PLANNING CONSULTATION RESPONSE

Application No	2025/0961
Proposal	2025 0961 C of U Vacant Chapel (Class F1) to Self-Storage (Class B8) Old Wesleyan Chapel Hoyland Road Hoyland Common
Address	Old Wesleyan Chapel Hoyland Road Hoyland Common
Date of Consultation Reply	18.12.25
Consultee	Tony Wiles Senior Conservation Officer

Consultation Assessment and Justification

Proposed GA Section B-B
Scale 1:50

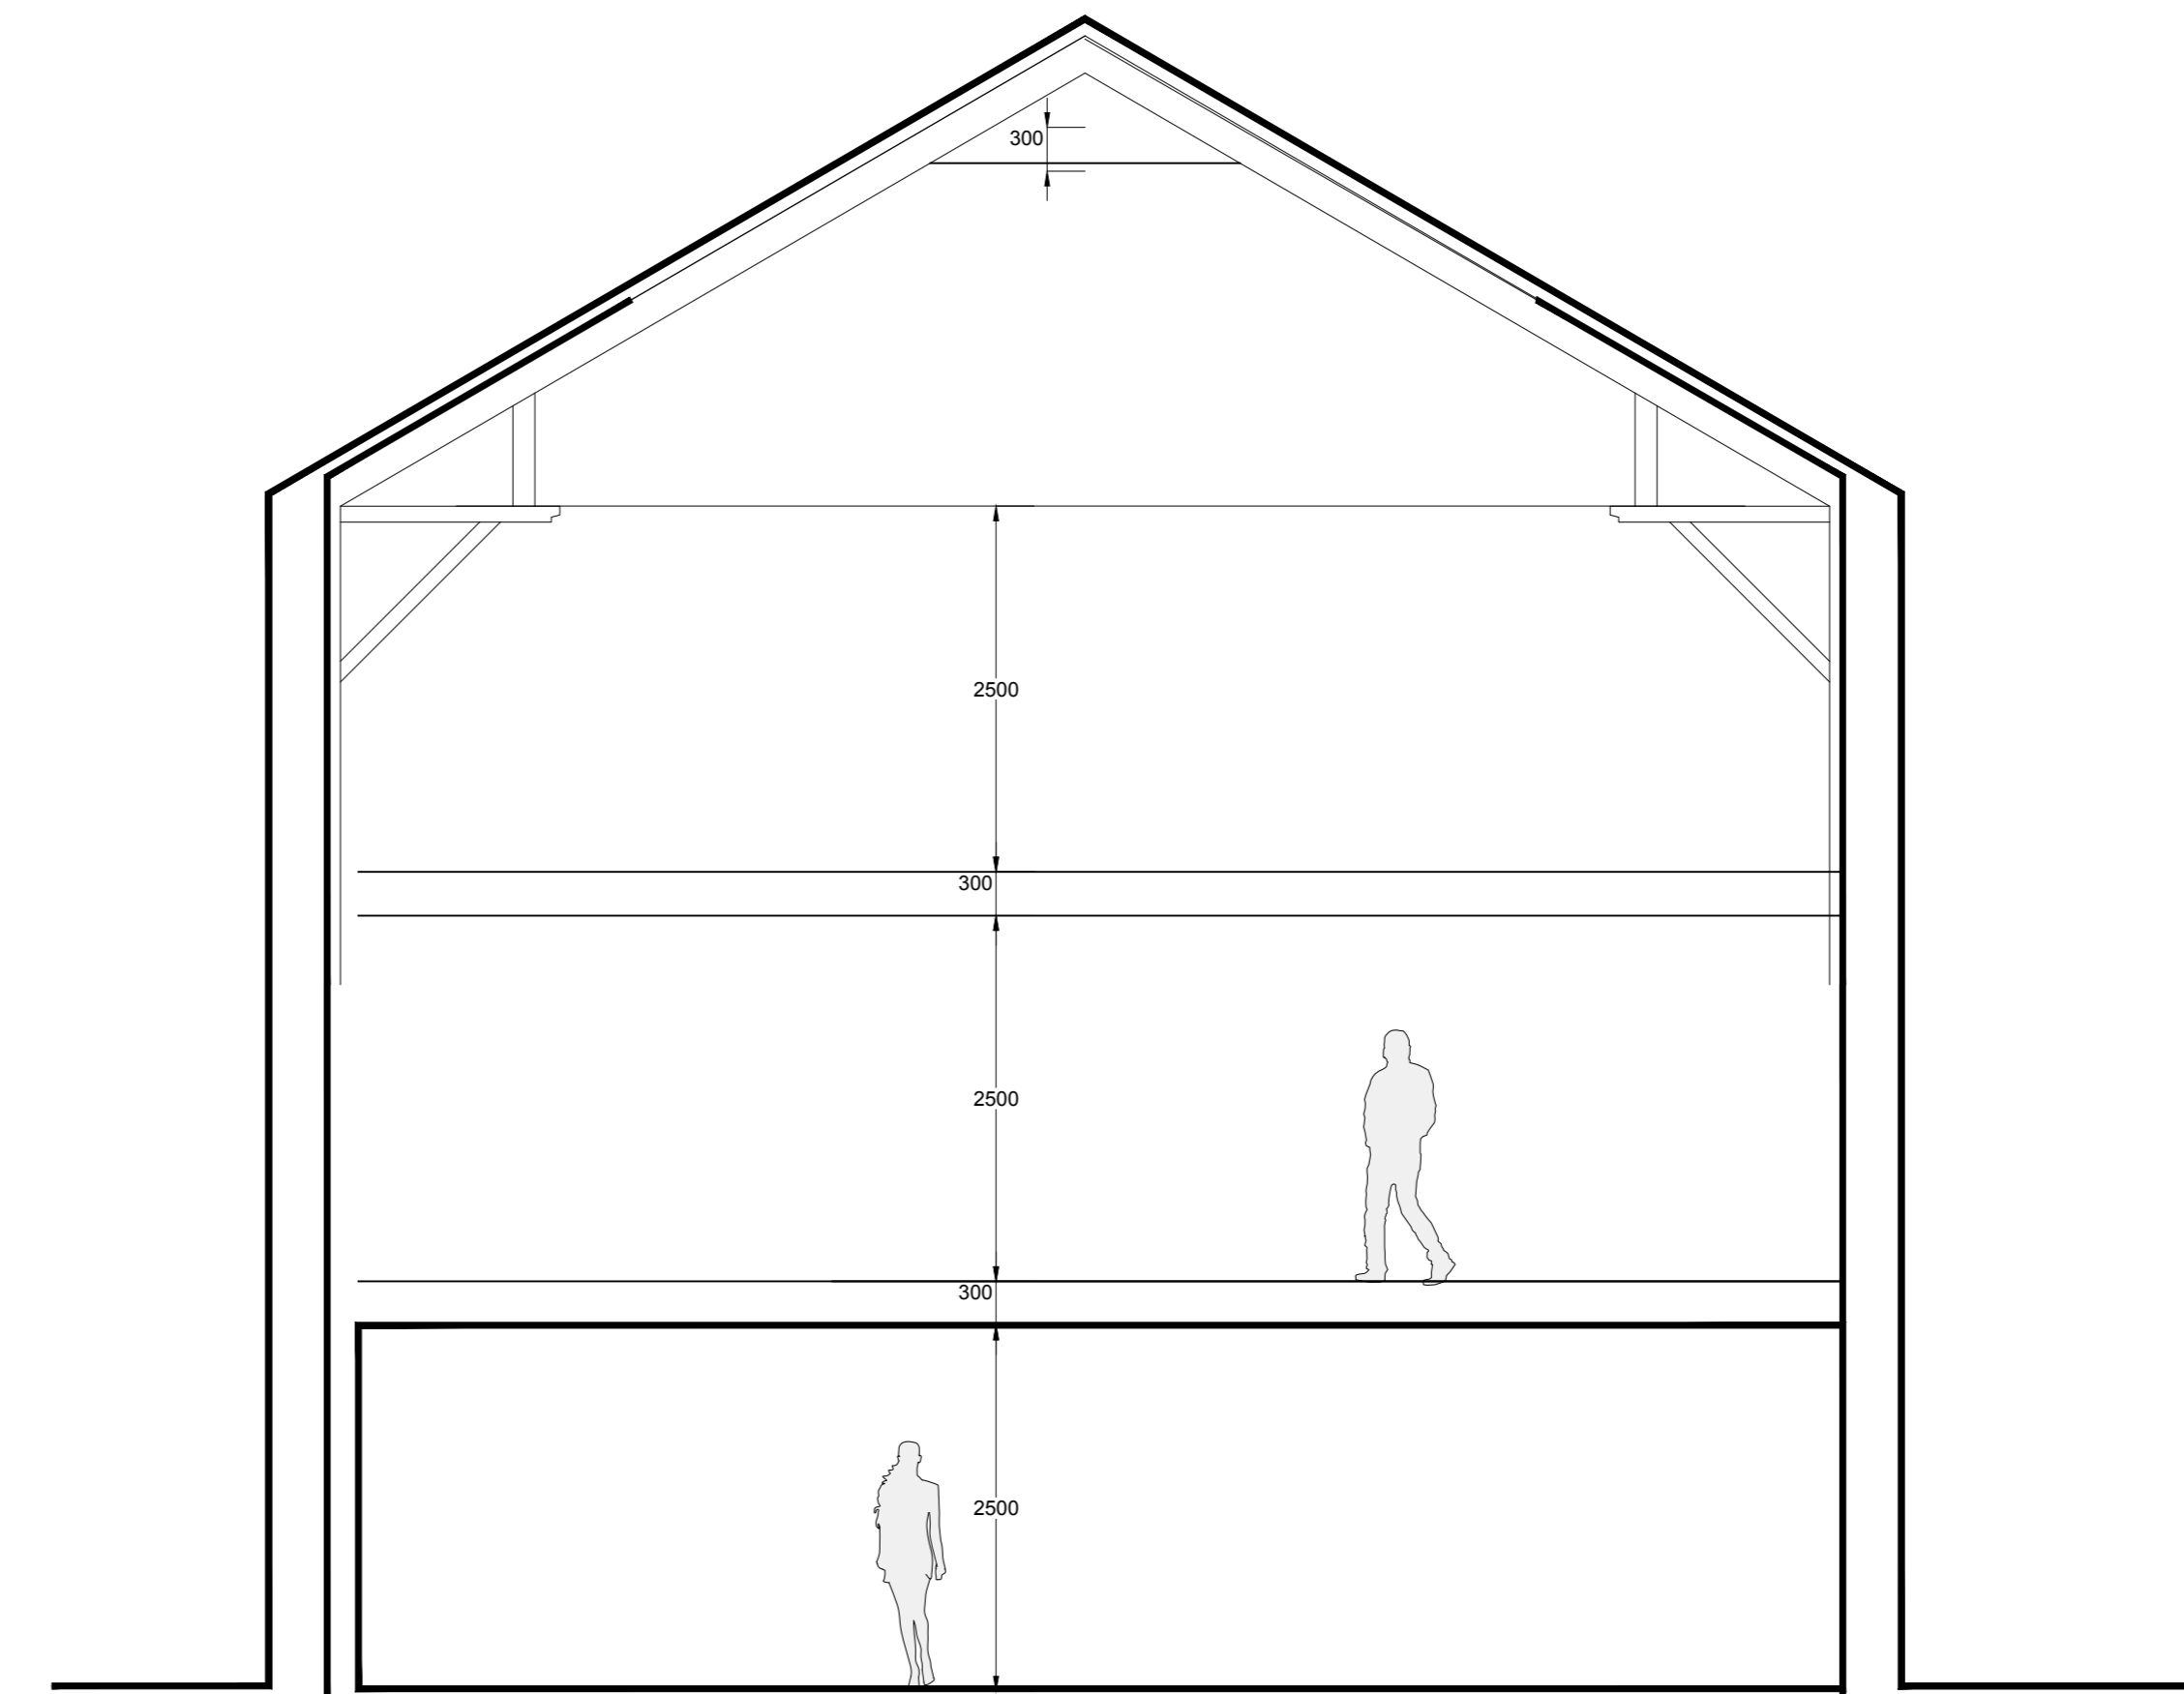
This application requests permission to change the use of the former Wesleyan Chapel on Hoyland Road, Hoyland Common from a place of worship to B8 – self storage. The proposal proposes no external alterations, but internally the auditorium and worship space will be demolished with a first and second floor inserted to provide storage space.

Externally, the chapel has an imposing stone-built frontage facing north onto Hoyland Road. This elevation retains much of its original detail, including a three bay / two (large) storey façade with a Flemish Gable, and a pediment at its apex. Smaller carved pediments top openings at ground floor level and there is a later porch (with pedimented inscribed date stone) covering a large three light mullioned opening (the top of which is just visible). At first floor level the windows are arched with voussoirs and the original frames and stained glass appear to be in situ. The side and rear elevations are much plainer and forgo ornamental detail for a robust but simple vernacular style in coursed stone with stone heads and cills. The roof retains its original Welsh Slate Covering. Whilst I know nothing of the interior or the condition of the building inside beyond its general layout, I can see from the plans it appears to retain its original auditorium, stage, and upper seating areas within. In terms of its character and quality I'd class the building as a non-designated heritage asset of some local value. Listed Wesleyan Chapels are somewhat rare in Barnsley but include the Salem Reform Chapel in Barnsley town and the United Methodist Free Chapel on Spark Lane. As such I feel this chapel is unlikely to be worthy of national listing. However, the front elevation is clearly of some quality and despite its condition contributes positively to the street scene. If it were in a decent state of repair, the building would obviously contribute far more. In terms of the internal changes, I would need to know more about the condition and degree of survival of original features to pass judgement on the proposal and whether total internal demolition and replacement is justified. I understand the building appears to have been vacant for some time following its former use as a kitchen showroom. As such, a new use that preserves the building fabric and its overall survival may be acceptable. However, this would need a fair degree of justification if that survival involved the wholesale loss of the internal worship space its existing plan form / arrangement or other features of merit.
